CITY OF ALBUQUERQUE

**Re: Lot 3, KRANIA, 140 98TH St.
Grading and Drainage Plan
Engineer's Stamp dated 8-22-13 (K09/D031B)**

Based upon the information provided in your submittal received 8-22-13, the above referenced Grading and Drainage Plan is approved for Building Permit based on the following conditions:

CITY OF ALBUQUERQUE
PUBLIC WORKS DEPARTMENT
ENGINEERING DEVELOPMENT GROUP
140 98th St. NW
KRANIA - LOT 3
GRADING & DRAINAGE PLAN

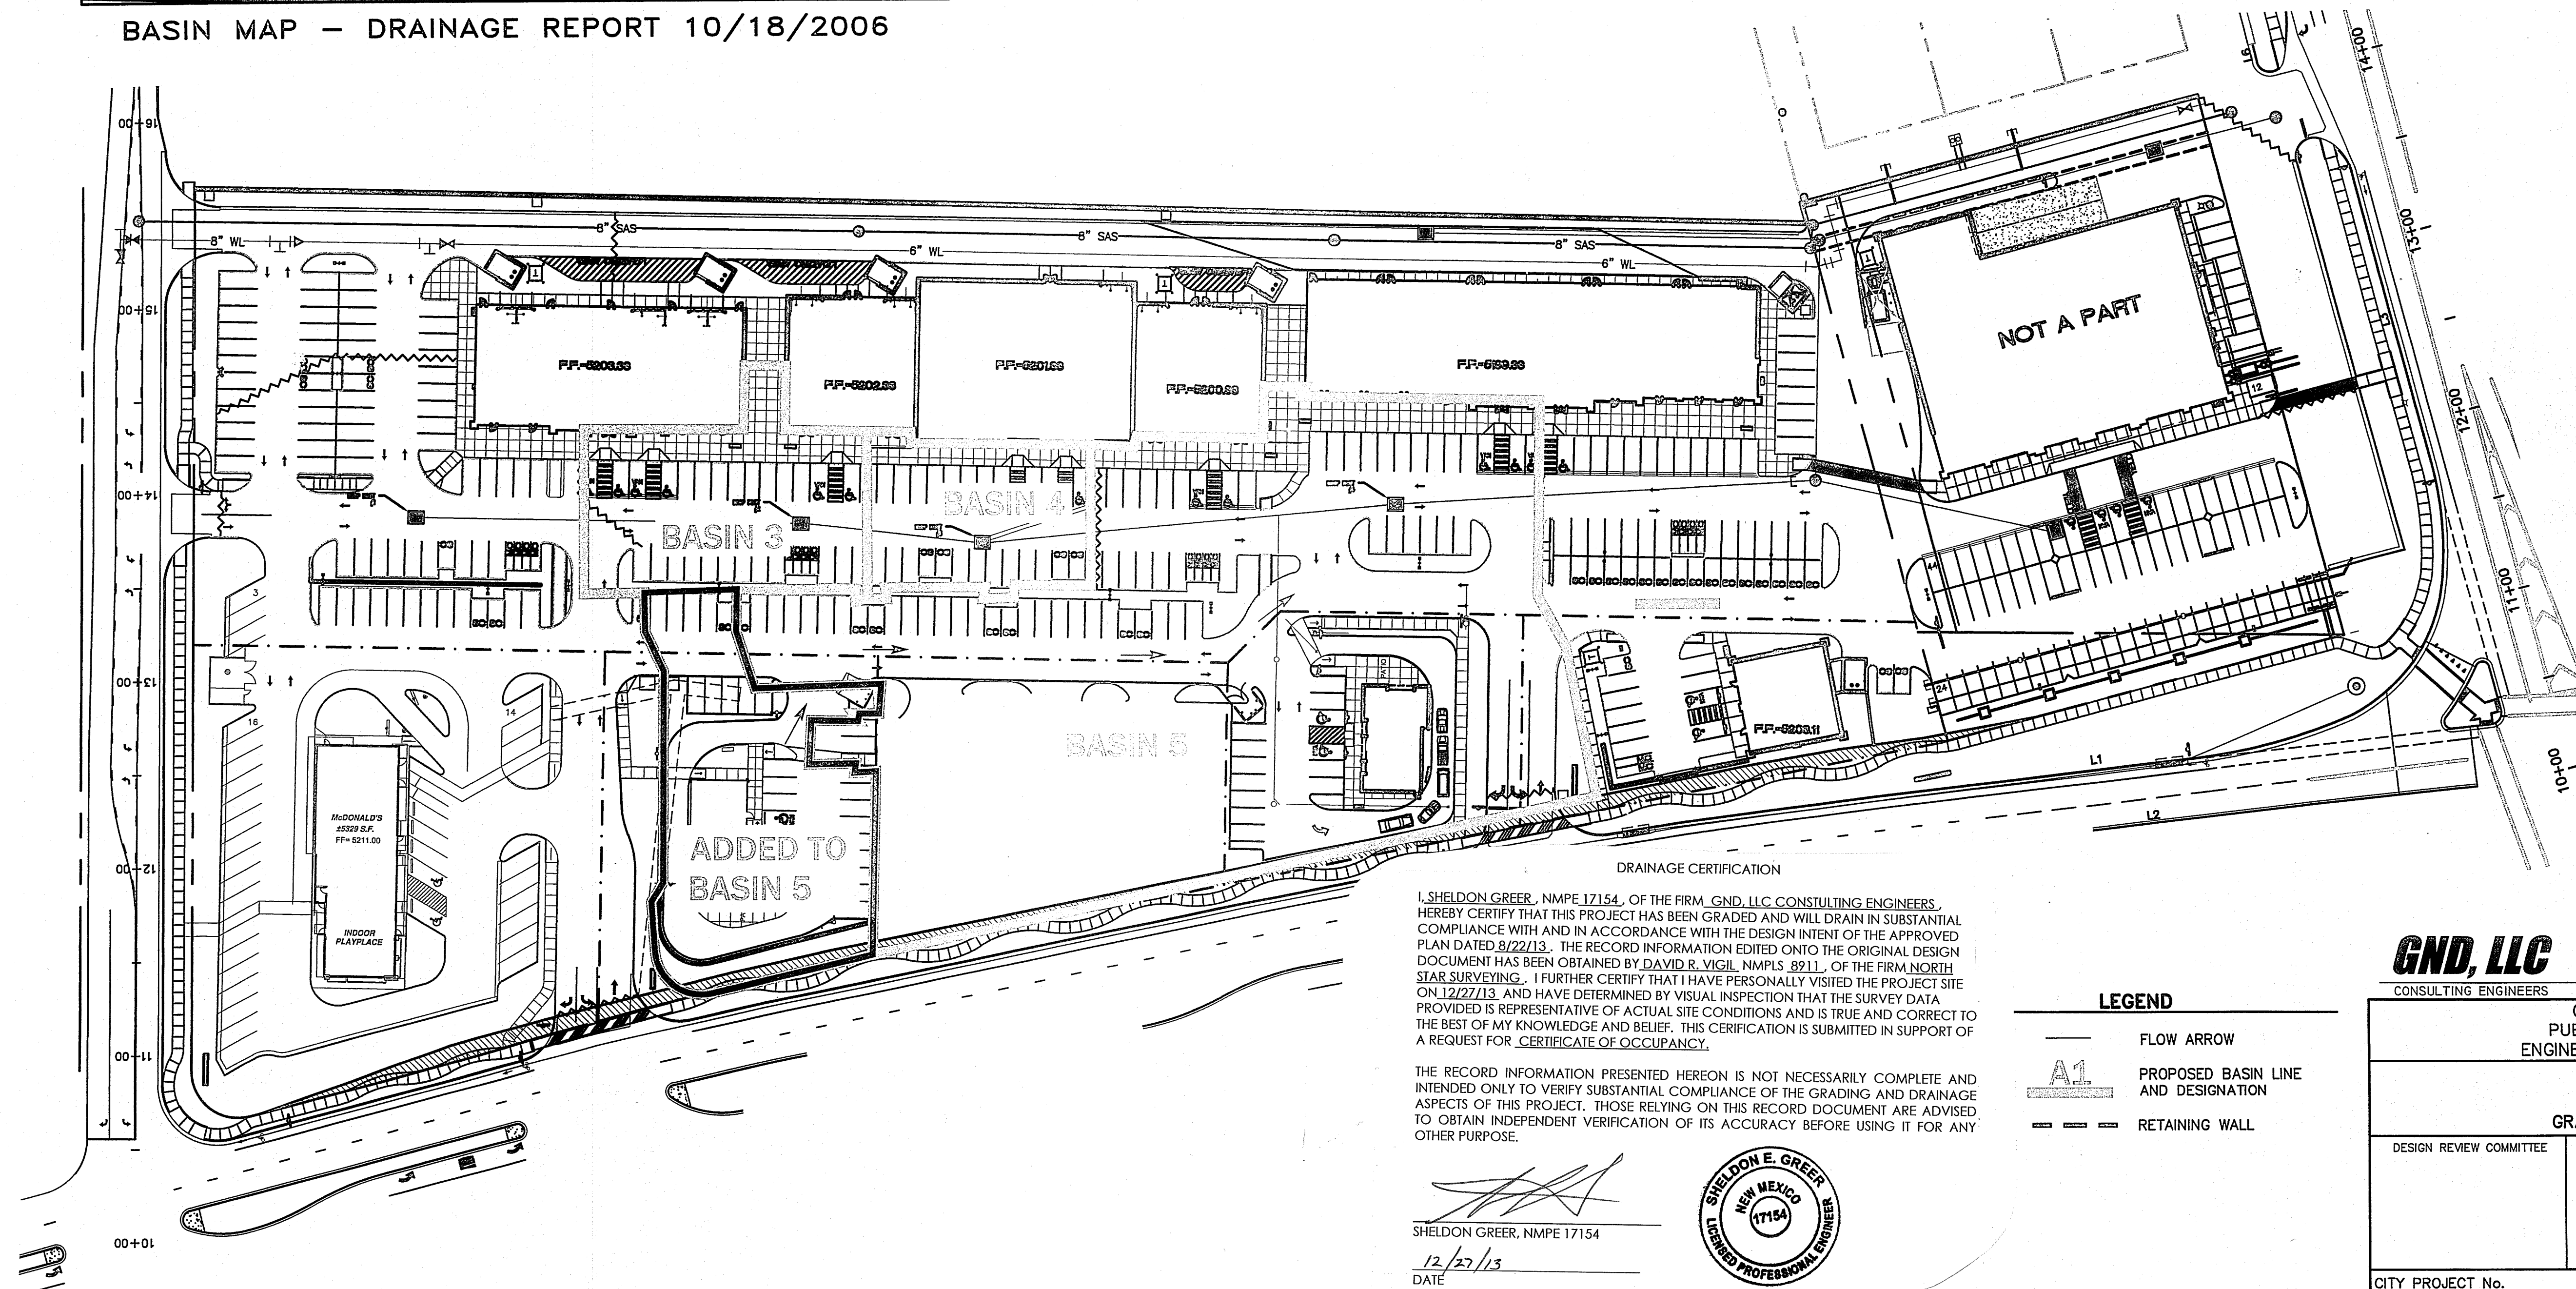
- Curb opening may be needed north of the depressed landscaping area near the sidewalk.
- Trash enclosure should drain to the center of the enclosure to a floor drain. From there the runoff should drain to an oil water separator and then to the sewer system.
- Handicap parking must be constructed with a maximum cross slope of 2%.
